Our ref: Minarah College (SSD-30759158)

17 August 2022

**Subject: Response to Submissions – Department’s Key Issues**

DRAWING TITLE				
EARTHWORKS GRADING PLAN (ULTIMATE DEVELOPMENT)				
PROJECT NO.	PLANSET NO.	RELEASE NO.	DRAWING NO.	REVISION
P2108320	PS02	R03	PS02-C100	B

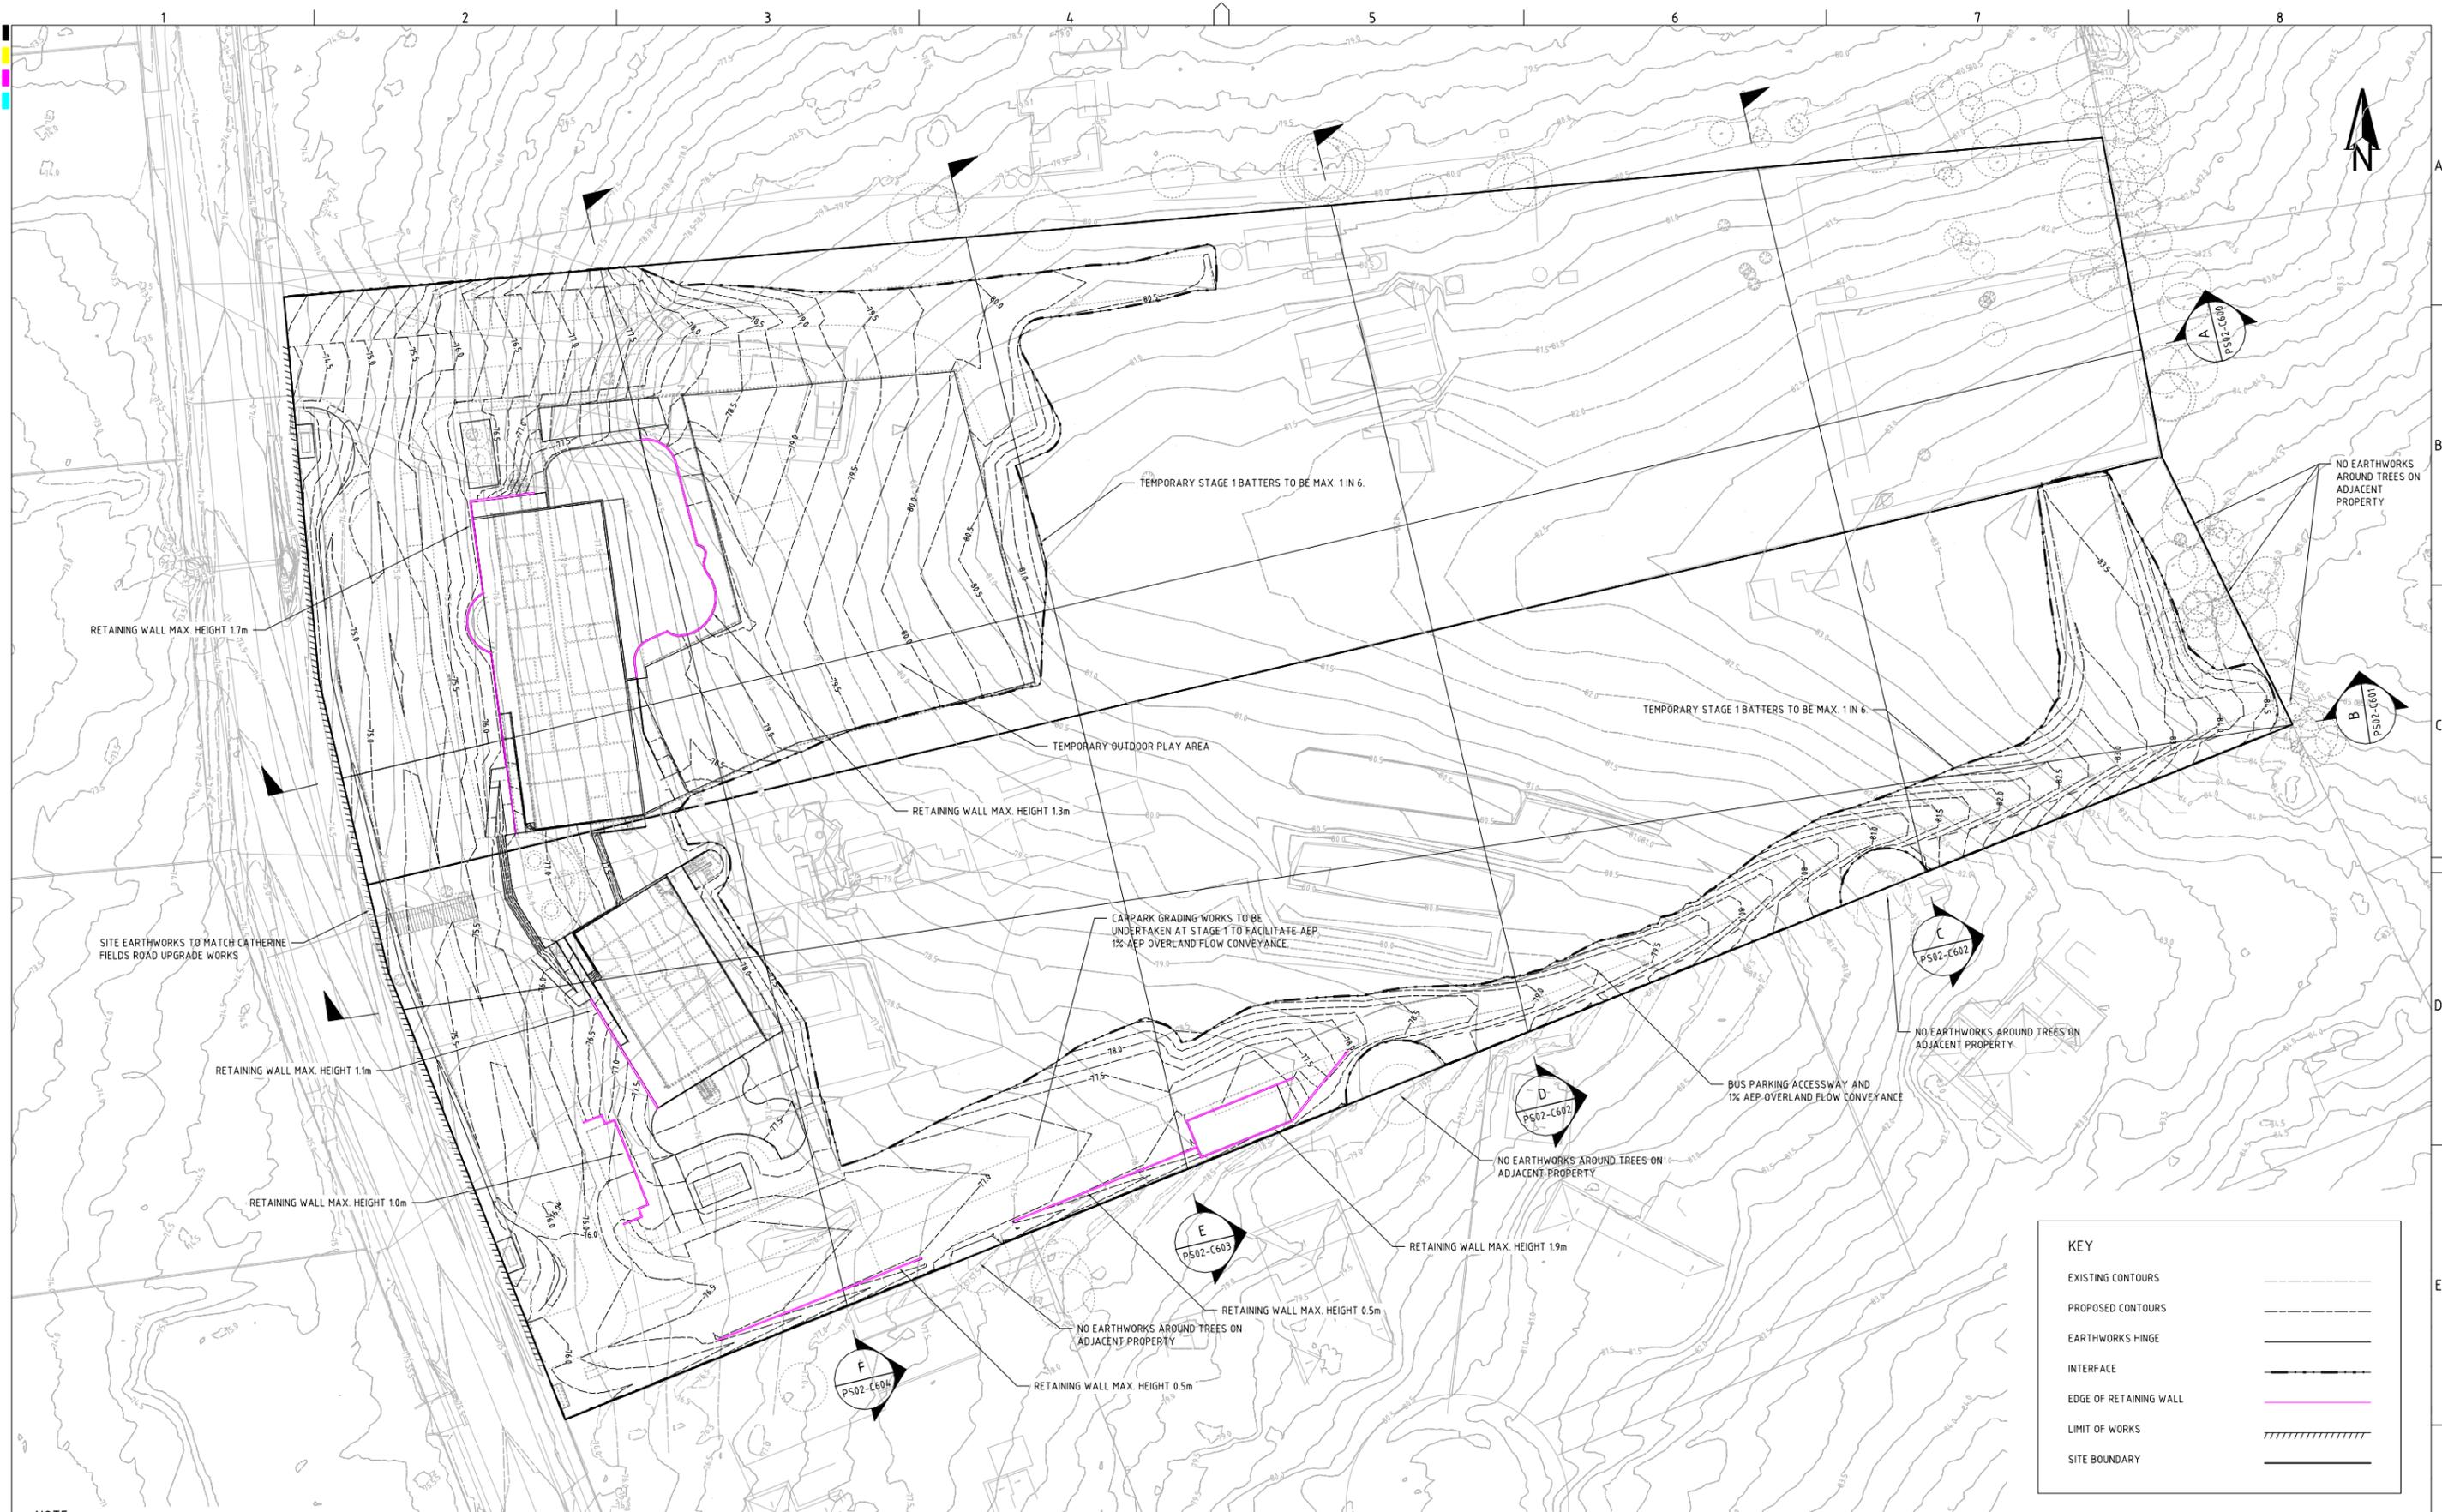
The Civil Works Plan at Appendix Q of the EIS includes earthworks grading plans, cut and fill plans, drainage plans and on-site detention plans for the ultimate development and Stage 1 only. As the SSD application seeks consent for all development stages, the Civil Works Plan must be revised as part of the RtS to include the relevant plans that correspond with each stage of construction proposed as part of the application (i.e. development Stages 1 to 5).

DRAWING TITLE				
DRAINAGE PLAN (ULTIMATE DEVELOPMENT)				
PROJECT NO.	PLANSET NO.	RELEASE NO.	DRAWING NO.	REVISION
P2108320	PS02	R03	PS02-E100	B

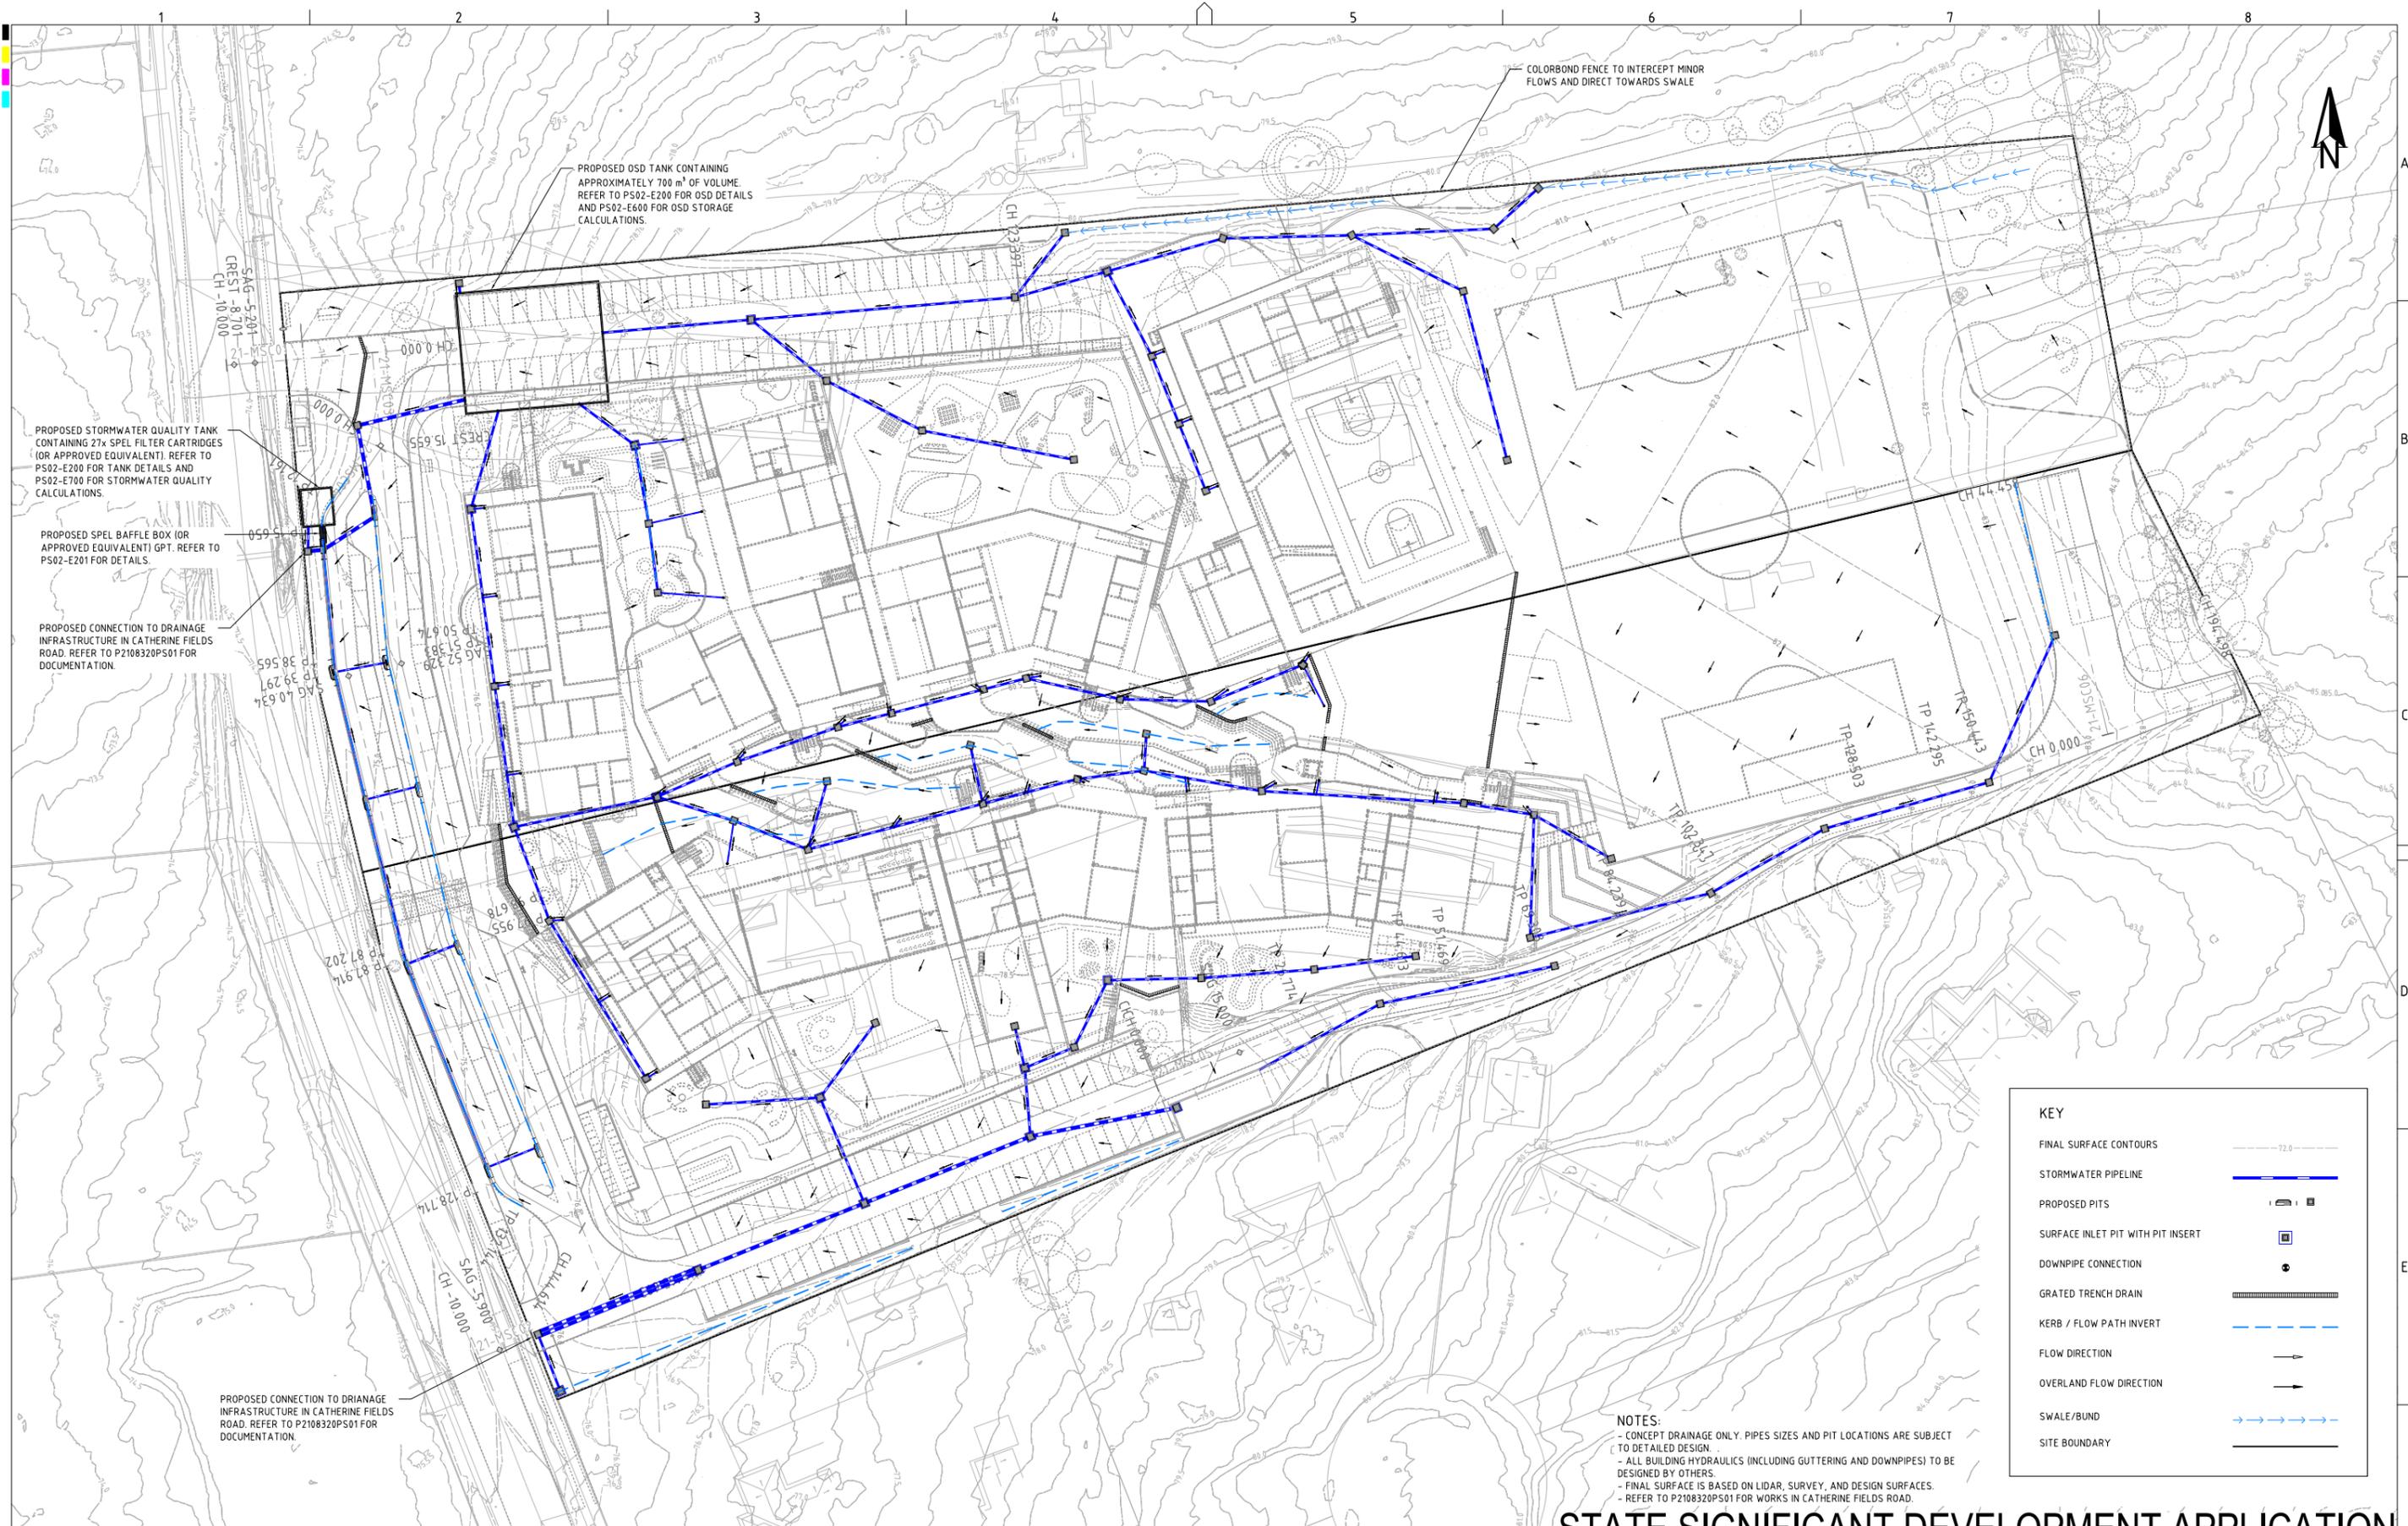
The EIS states that overland flow paths would direct stormwater away from buildings and ultimately discharge to the Catherine Fields Road reserve drainage system. As noted in Camden Council's submission, there is no piped underground stormwater drainage infrastructure provided along Catherine Fields Road. Therefore, there is a risk that flows from the site may impact on downstream properties and/or find its way to nearby watercourses such as South Creek during high rainfall events.

The RtS must confirm that the proposed stormwater drainage regime would not adversely impact on any downstream properties, nearby watercourses or riparian land. Mitigation measures should be proposed where potential impacts are identified.
